Planning Application No: 3/2024/0759

Proposal: Proposed two storey extension to side and rear with first floor balcony and glazed canopy over patio area to rear.

Location: 22 Willows Park Lane Longridge PR3 3HJ

Stephen Marle			
22 Willow Park Lane, Longridge		Dwg No.	Rev.
Existing and Proposed Site Layouts		A4133/PL13	
		Scale	Sheet Size
		As Shown	A2
		Date	
		August 2024	
		Drawn	Checked
		DME	Approved

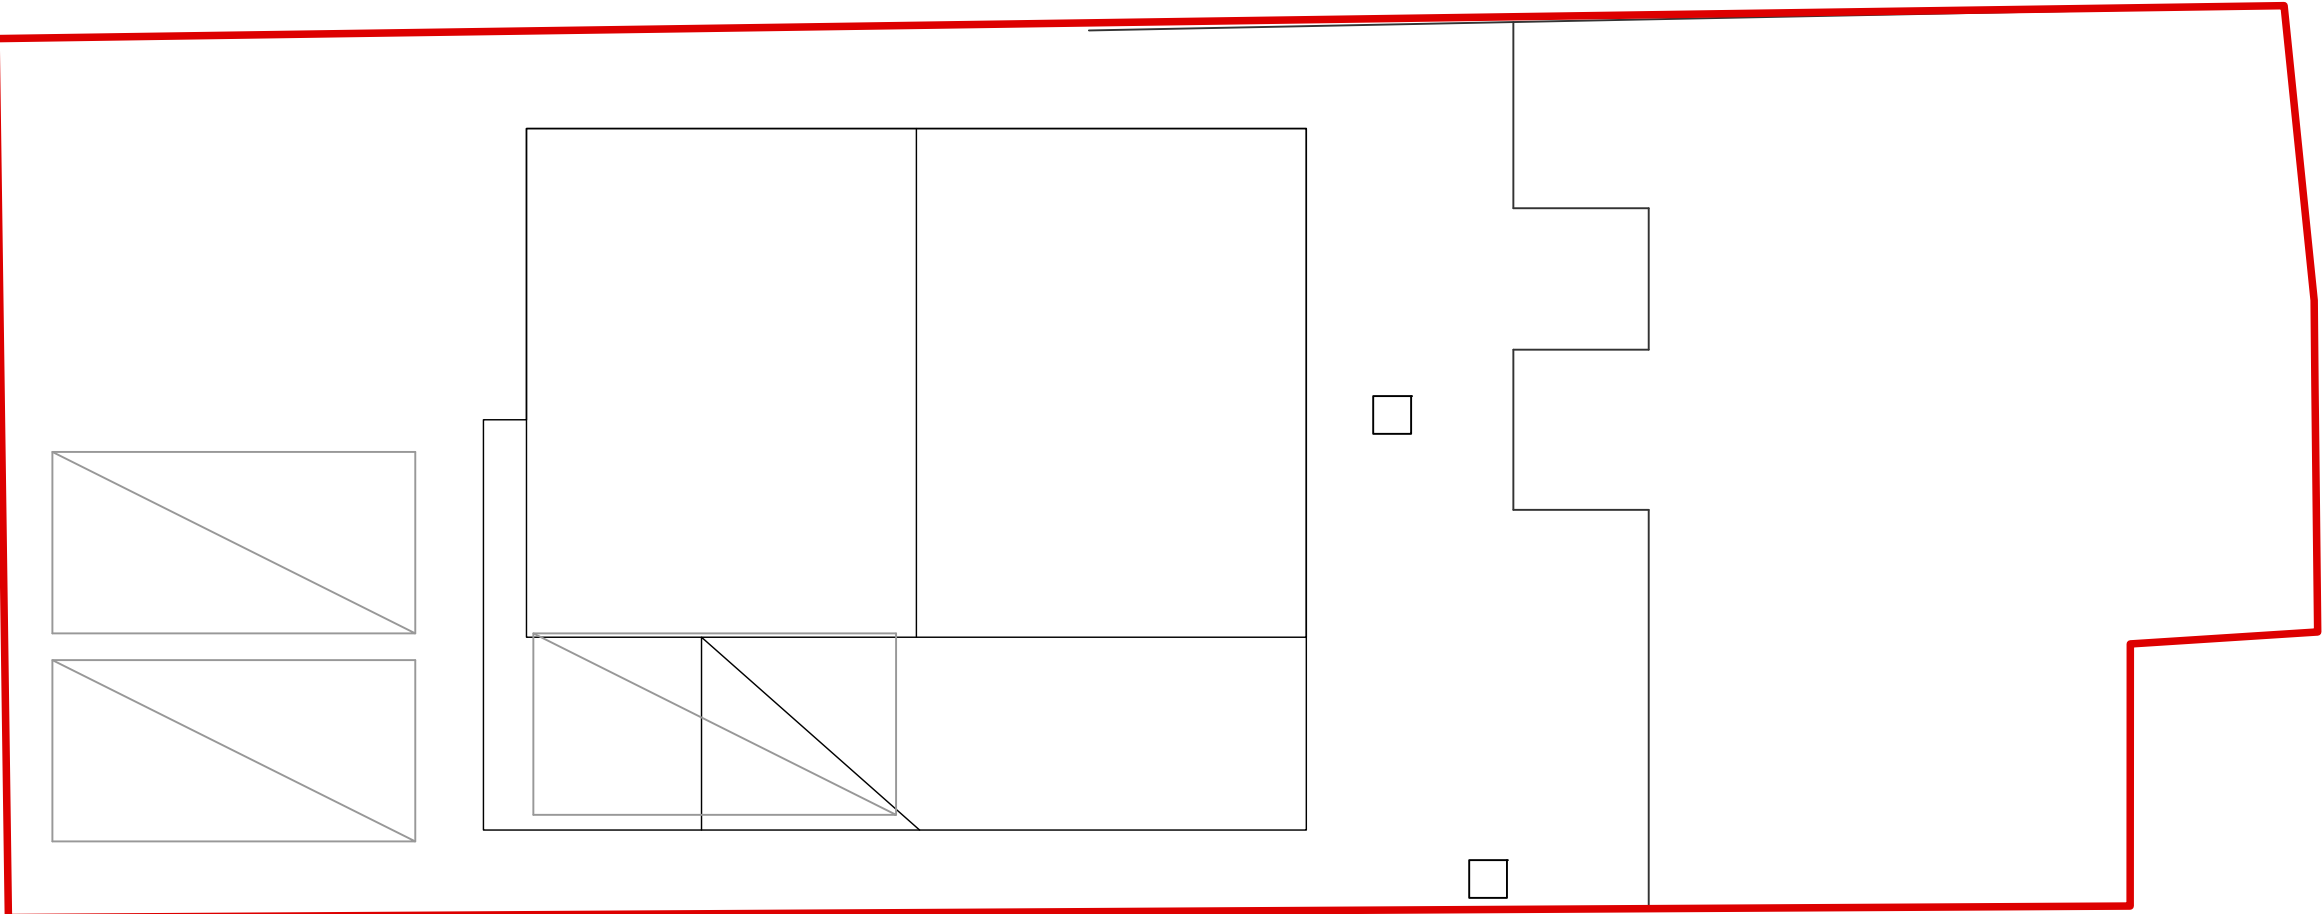
Our previous comments remain. An adequate level of off-road parking for the type and size of development proposed will be retained (ref. Drawing no. A4133/PL13, Aug 2024, Site Layout submitted). The highway authority is of the opinion that the proposed development will not have a significant impact on highway safety, capacity or amenity in the immediate vicinity of the site. There is no objection to this proposal.
